**KIRKLEES METROPOLITAN COUNCIL
INVESTMENT & REGENERATION SERVICE**

DELEGATED DECISION TO DETERMINE PLANNING APPLICATIONS

Reference No:	2024/62/91377/W
Site Address:	22D, Howgate Road, Slaithwaite, Huddersfield, HD7 5AY
Description:	Erection of single storey extension to front
Recommending Officer:	Joanna Rednall

HOUSEHOLDER DELEGATED REPORT

Title
Layouts and elevations.

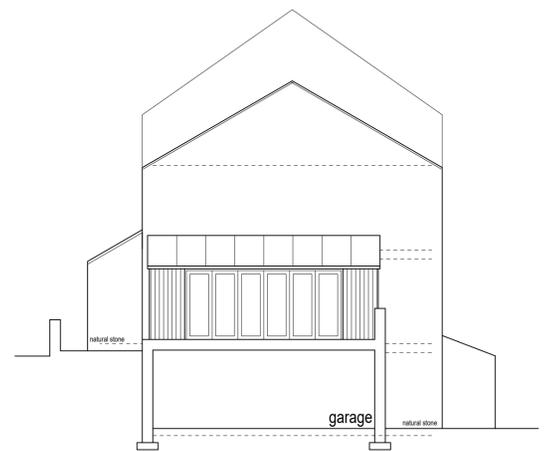
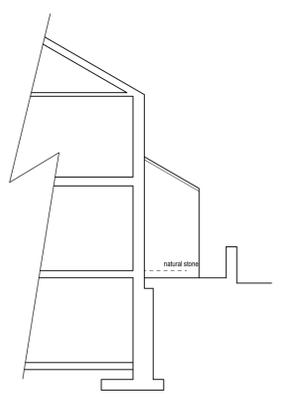
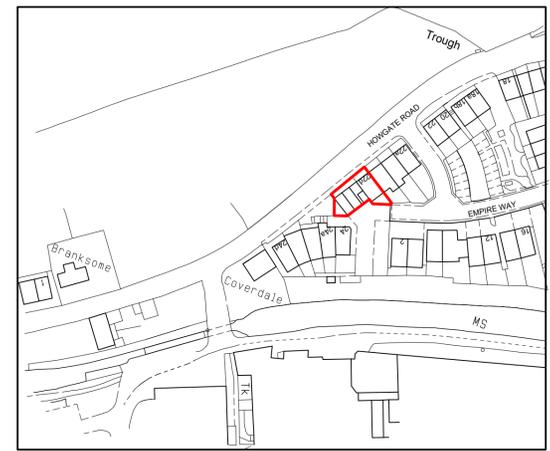
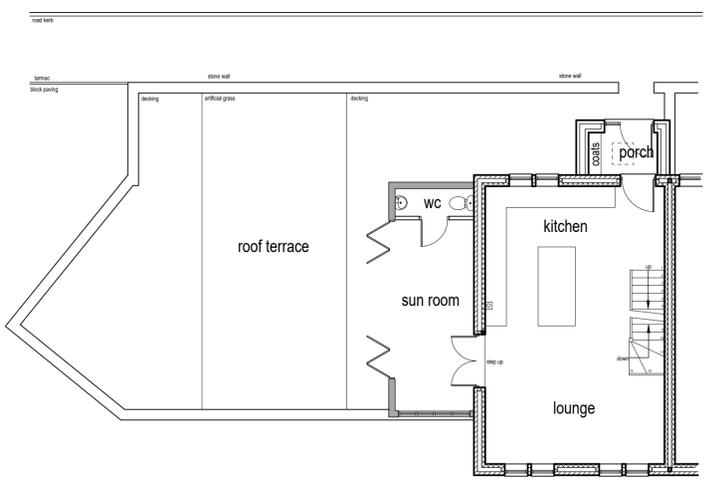
YES / NO	SUMMARY
Negotiations/Amendments during course of application	Yes	Amended plans were sought to reduce the width of the scheme to reduce the impact on visual amenity. Amended plans were received 25 th September 2024 that addressed the concerns raised, these have been used in the determination of this application.
Parish/Town Council comments sought	No	
Planning History	Yes	2022/91612 Erection of extensions and alterations <i>Conditional full permission</i>
Consultations required	No

- ~1.6m projection
- ~2.7m width
- ~2.5m eave height
- ~3.4m ridge height

The extension is constructed from natural stone with a lean-to roof infilled with concrete tiles.

Single storey front extensions permitted where:	<u>Yes - COMPLY</u>	<u>No - JUSTIFY</u>
The house is set well back from the pavement or is well screened.	The house is set back approx. 2.6m from the pavement with front boundary treatments consisting of small stone walls.	
The extension is small, subservient to the original building, well-designed and would not harm the character of the original house or area.	The front extension is limited in terms of its projection and height, and the extent of the extension would remain separated from the front boundary of the curtilage. Following discussions with the applicant's agent, the width of the extension has been reduced to minimise the development's impact on the street scene. The reduced scheme appears proportionate and subservient to the host property.	
The materials and design match the existing features of the original house	Natural stone walls and concrete tile roof to match the original house.

Amended plans were sought to reduce the width of the scheme to reduce the impact on visual amenity. Amended plans were received 25th September 2024 that addressed the concerns raised, these have been used in the determination of this application.
